From: Eric Carvill [REDACTED]
Sent: 30 April 2019 19:41
To: Juan Baeza
Cc: [REDACTED]
Subject: FG/1/19/PL

DRW NO 4b SCALE 1/50 (A3)
PROPOSED ROOF PLAN

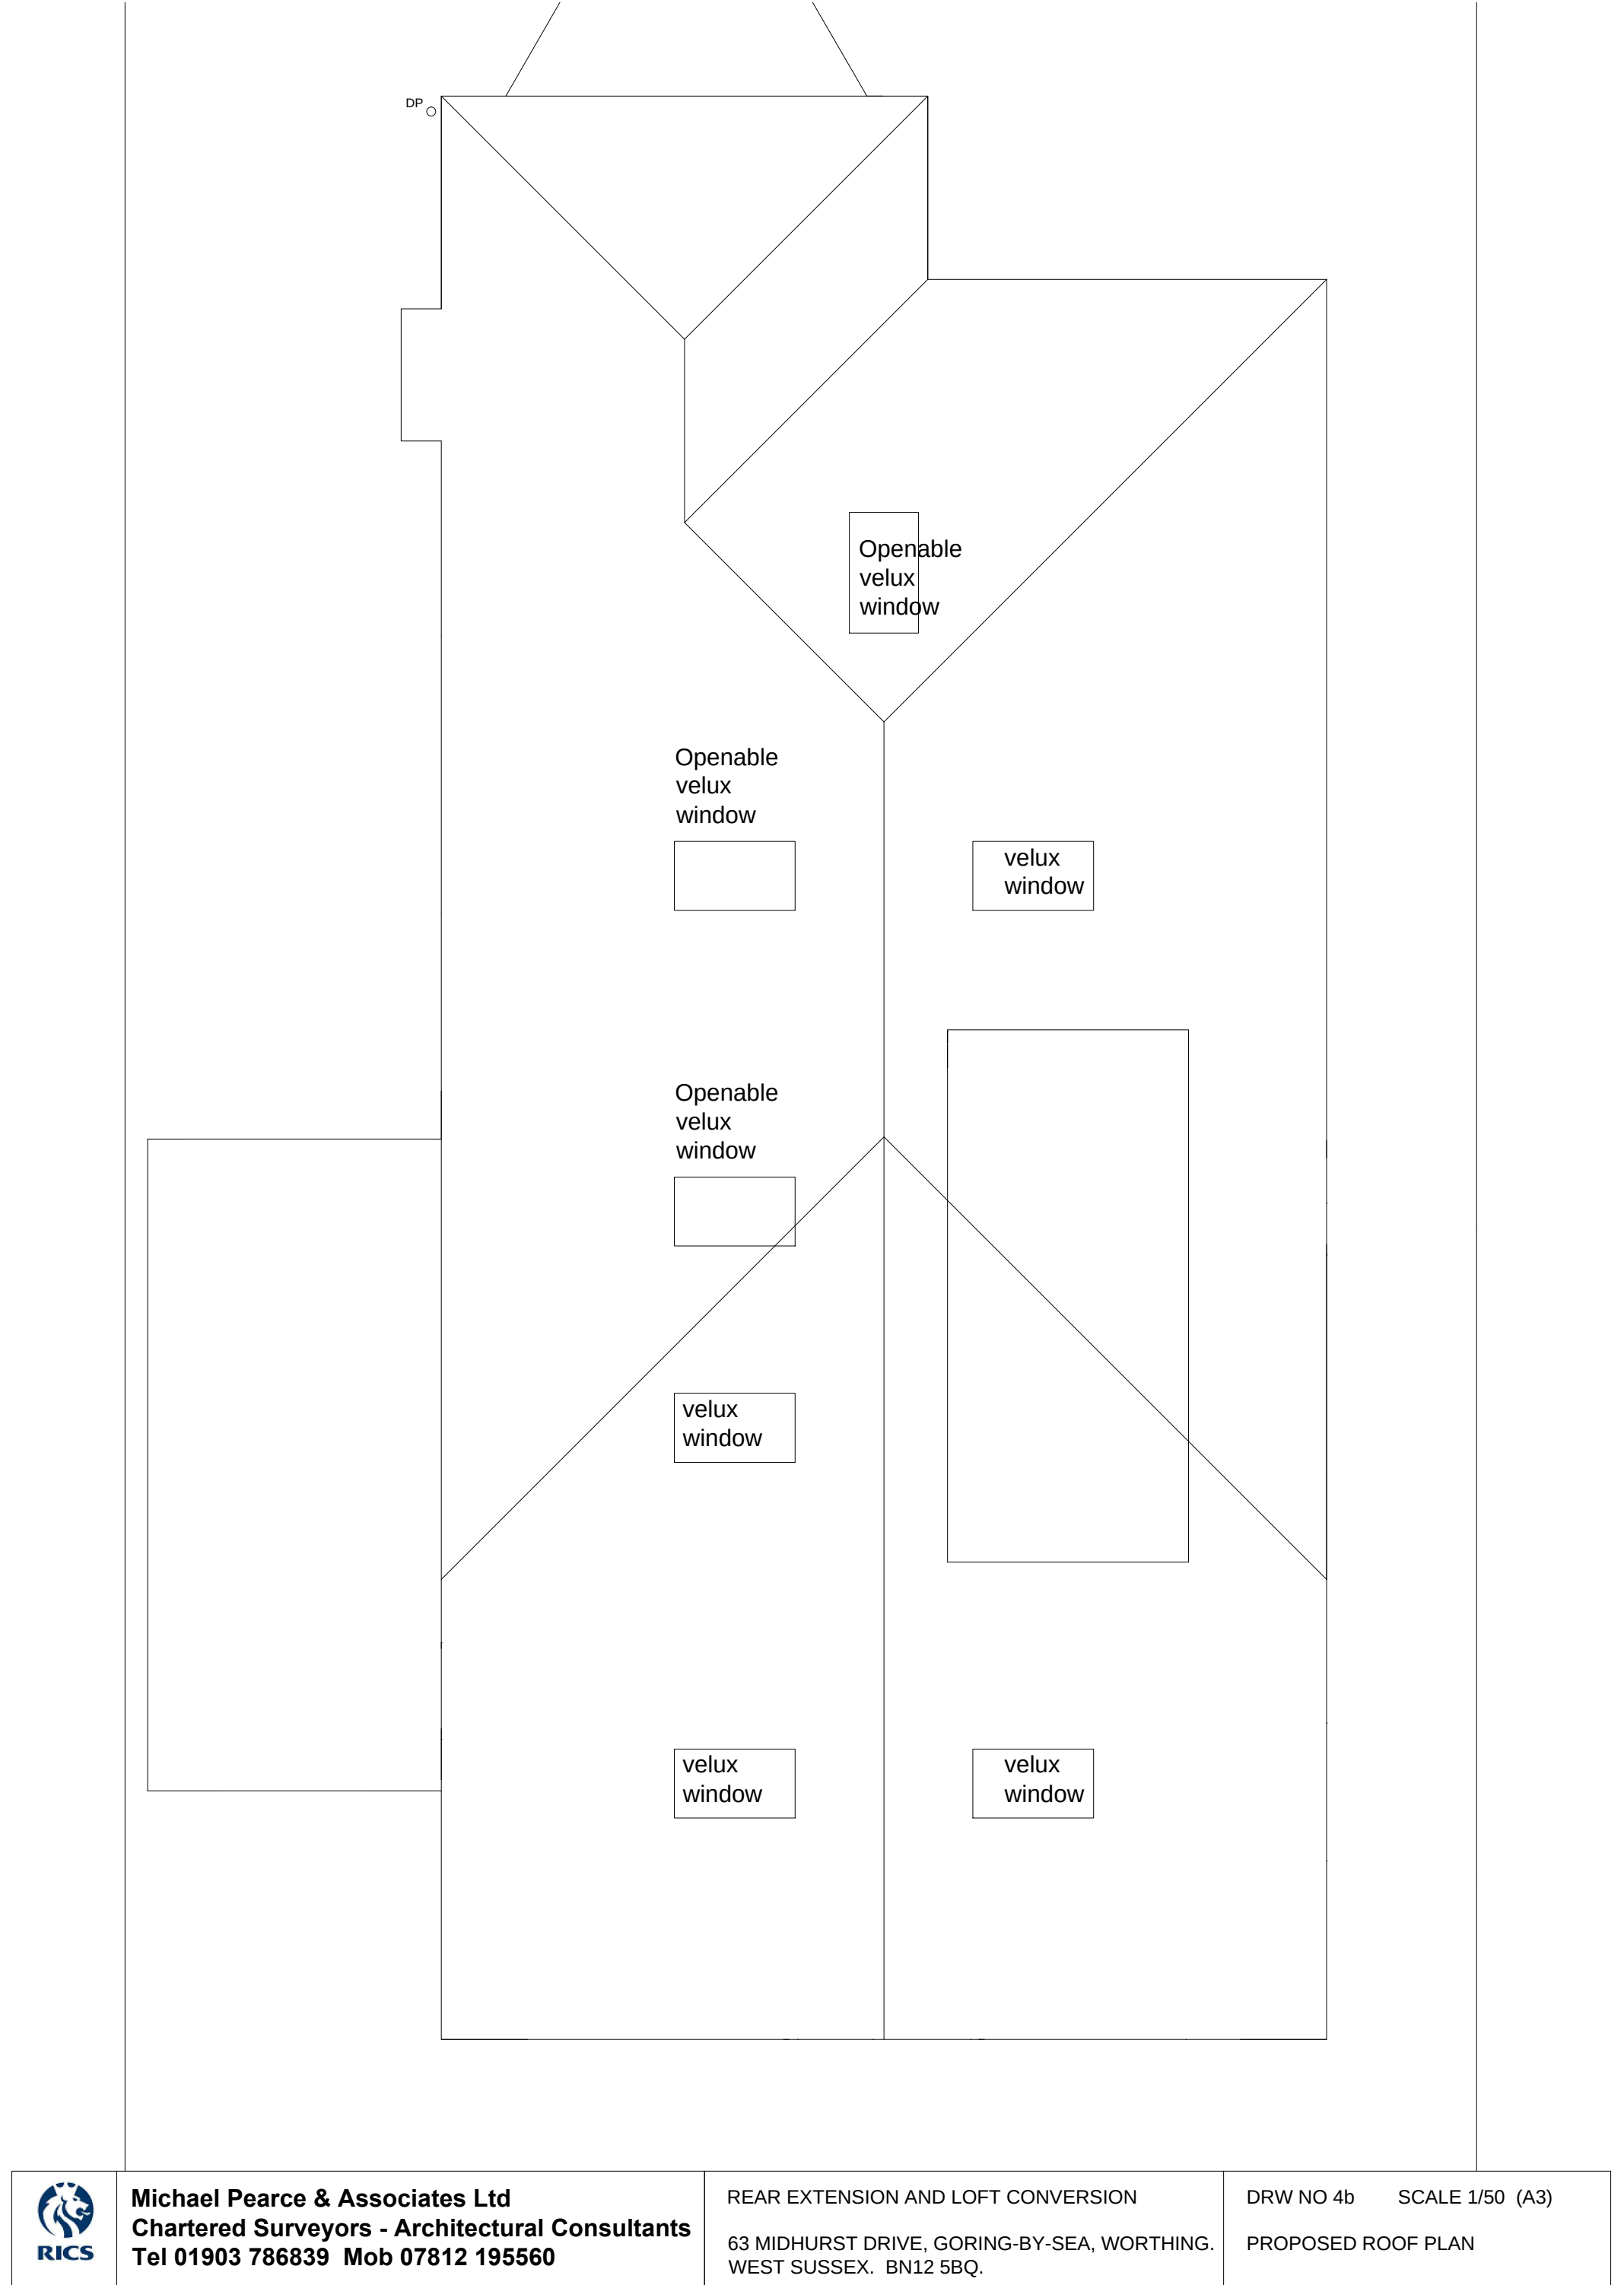
Velux is not the only manufacturer of pitch roof windows
Fakro make pitch roof non opening windows and so does a company called ECO+RESET, full details are on their websites and roofing supply company websites.
Velux do in fact supply their top opening roof windows with an obscure/ opaque glass. An example is GPUMK040034.

So asking to open a window that should not be openable, is like saying I am here now, I must be opened.
A bit like putting the cart before the horse
Other people manage to clean and maintain their windows from the outside.
Why not number 63.

The main objection is to the two windows in the extension part which overlooks several gardens.
